DEVELOPMENT REVIEW BOARD  
TRANSPORTATION DEVELOPMENT

DRB Project Number: 1010675  
Shops @ PDN

SUBJECT: Preliminary/ Final Plat, Vacation Of Private Easements

SITE PLAN

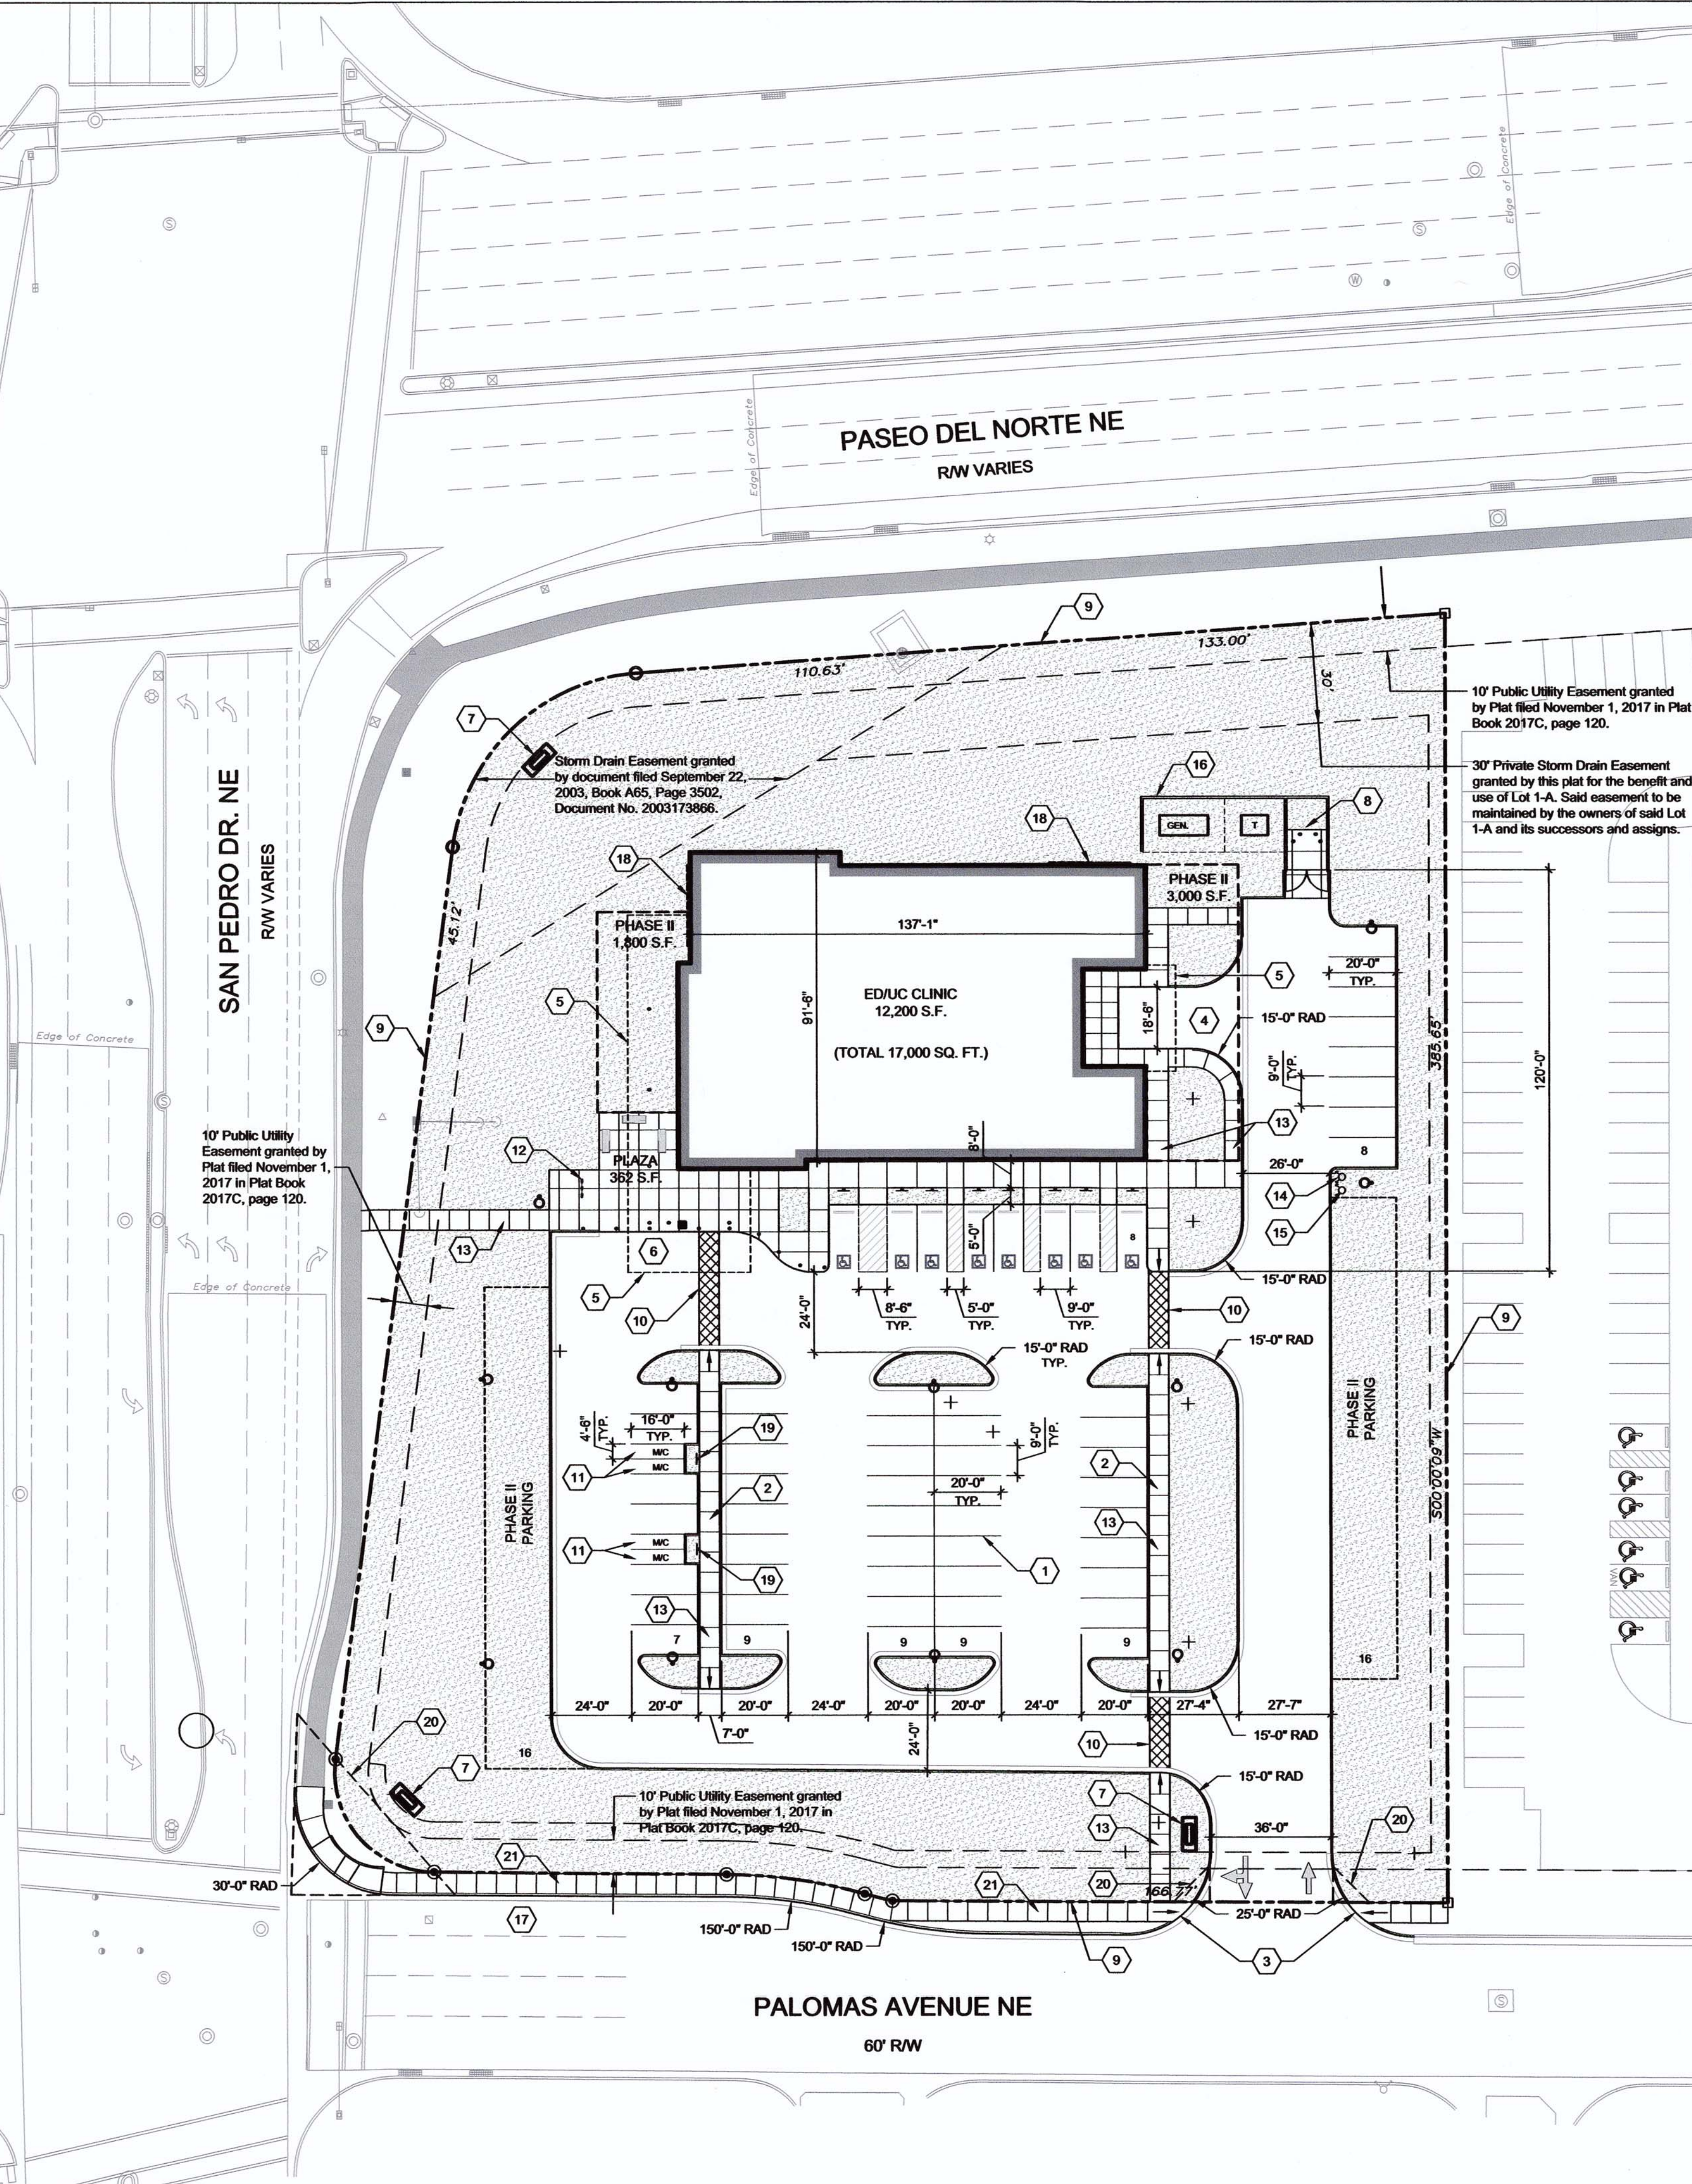
1. Provide an updated site plan for building permit.
2. Provide an updated infrastructure list.
